Ribble Valley Borough Council
Housing & Development Control

Application no: **3/2023/0725**

Address: **Pewter House Farm Commons Lane Balderstone BB2 7LN**

Proposal: **Change of use of three adjoining steel portal frame agricultural structures to five dwellings under Class Q (a) and (b) of the GPDO. Resubmission of application 3/2022/0909 and 3/2022/1072.**

CLIENT DETAILS	DRAWING No	REVISION
CARR LANE BALDERSTONES RIBBLE VALLEY	RBV-PL-008	
DRAWING INFO	SCALE	DATE
Proposed Site Layout	1:500	05/09/22 DRAWN BY JH

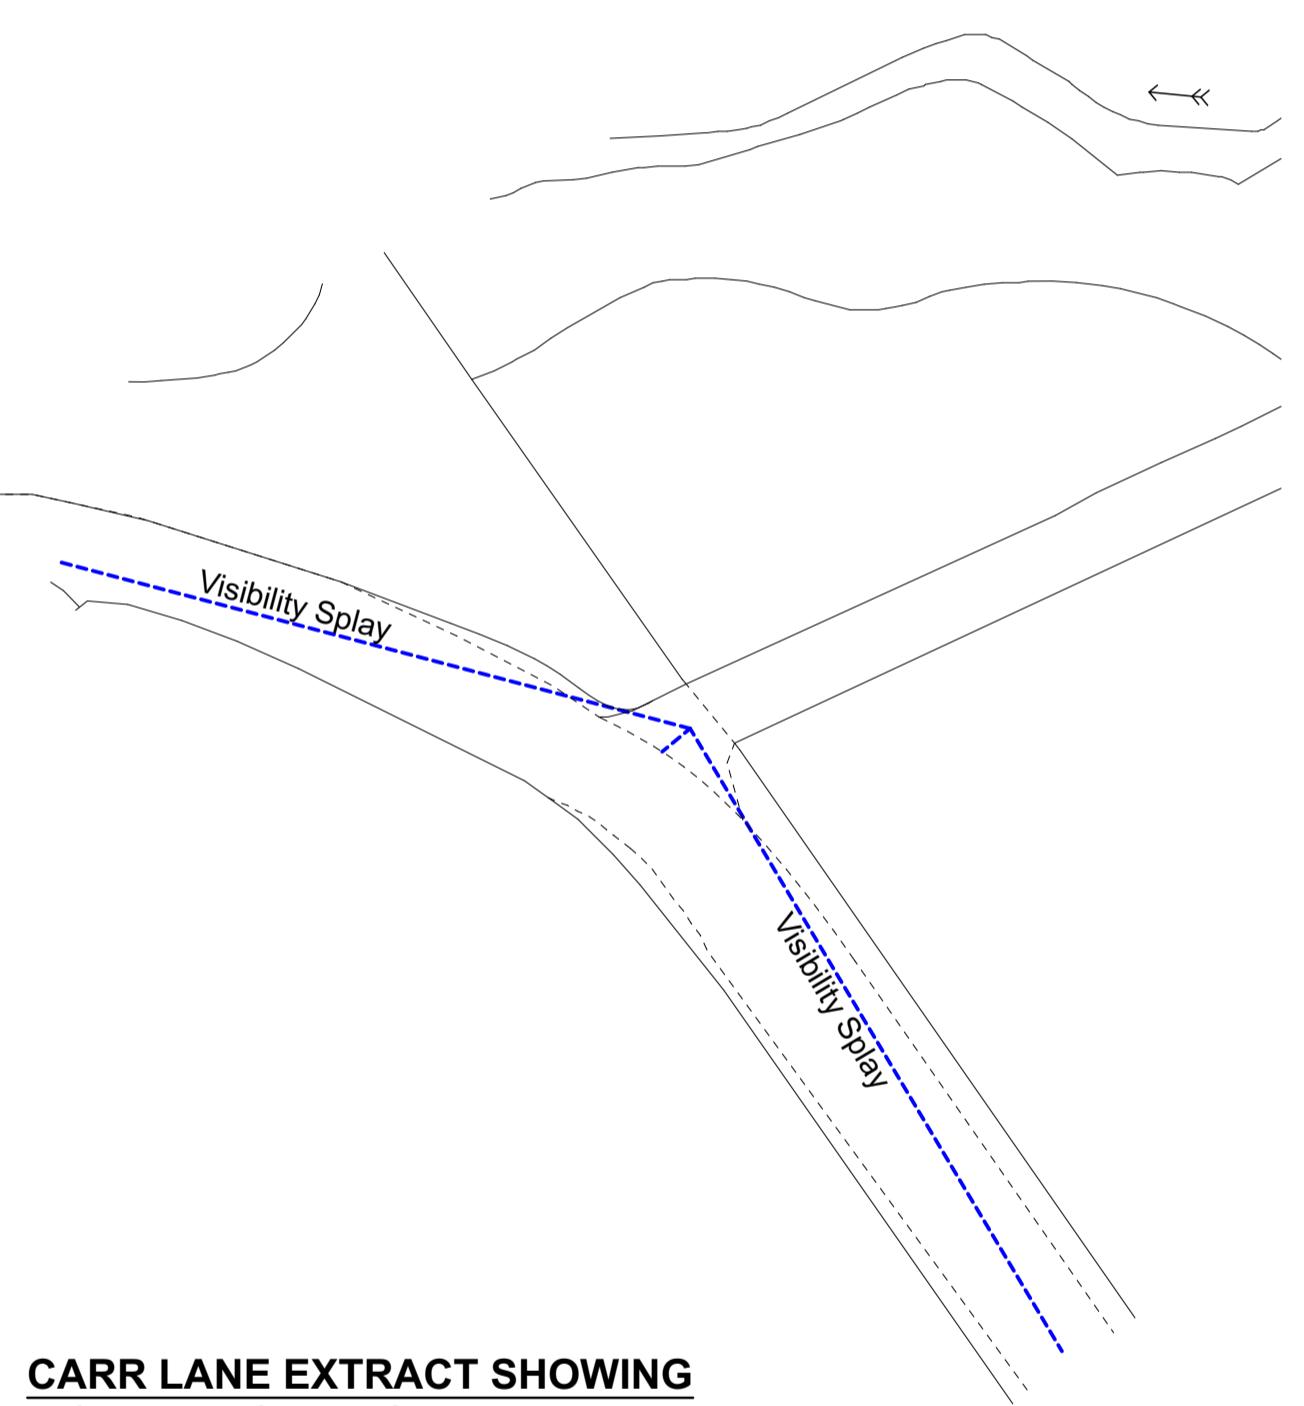
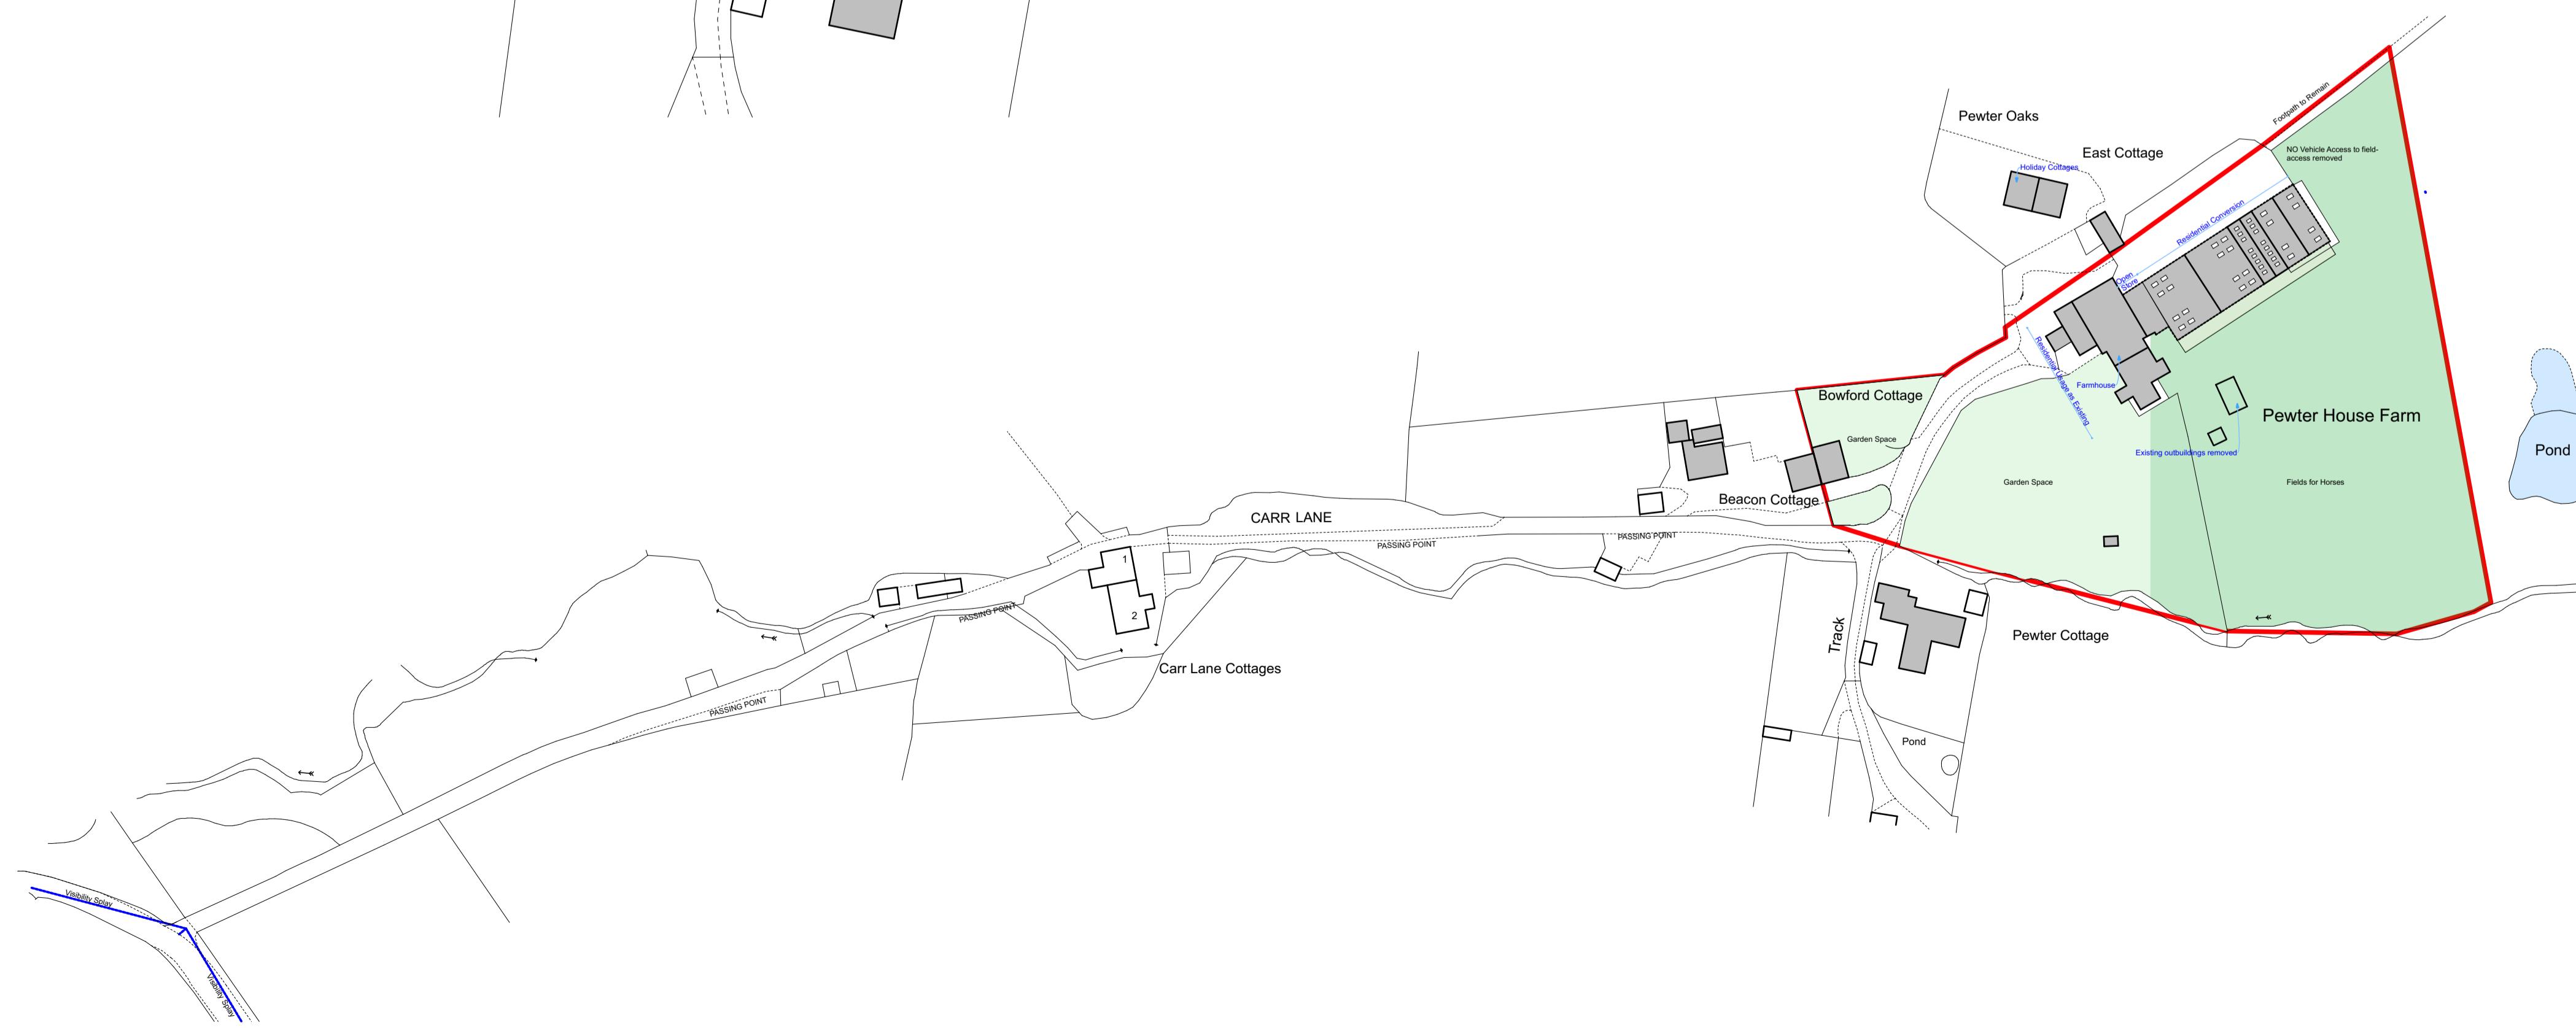
The LHA have reviewed C49 drawing number RBV PL 008 titled "Proposed Site Layout" and are aware that the drawing shows that the Commons Lane/ Carr Lane junction can provide visibility splays of 2.4m x 43m in both directions.

However, the LHA are concerned that the OS map the Agent has used to provide the visibility splay drawing is not accurate. This is because OS has a tendency to be inaccurate in rural locations such as this. Therefore, the LHA are concerned that the visibility splays at the junction may overlook third party land which is unacceptable due to the Applicant being unable to prevent any obstructions being implemented within the splays which would impact upon visibility and in turn highway safety.

C49 drawing number RBV PL 008 titled "Proposed Site Layout" also shows that the access width is a minimum of 5m wide for a total distance of 3m from the adopted highway. The LHA again dispute the reliability of the OS map with the map not considering the grass verge provided on both sides of the access track, as shown on Google Streetview with images from February 2023 and during the site visit. Even if the drawing is accurate, the access should be a minimum of 6m wide for a distance of 10m behind the highway boundary given that the access serves numerous dwellings and agricultural holdings. Therefore, the LHA are concerned that the proposal will intensify the use of a substandard access which is not within the Applicants red line boundary.

The LHA have used Mapzone, Lancashire County Councils digital mapping software and are aware that Carr Lane, from the access to Pewter House Farm, is approximately 540m in length. For the most part, as shown on C49 drawing number RBV PL 008 titled "Proposed Site Layout," Carr Lane is approximately 1.9m wide and has access to 4 passing places along its length.

The LHA dispute the number of passing places which have been recorded on the Agents drawing. This because following a site visit and as shown on Google Streetview, the passing place which is located approximately 250m away from the site access can only be classed as a formal passing place while the others are informal and located on third party land. Therefore, there is no guarantee that the informal passing places can be used on a regular basis should two-vehicles meet on the single tracked lane, with some of these passing places being accesses or parking areas.
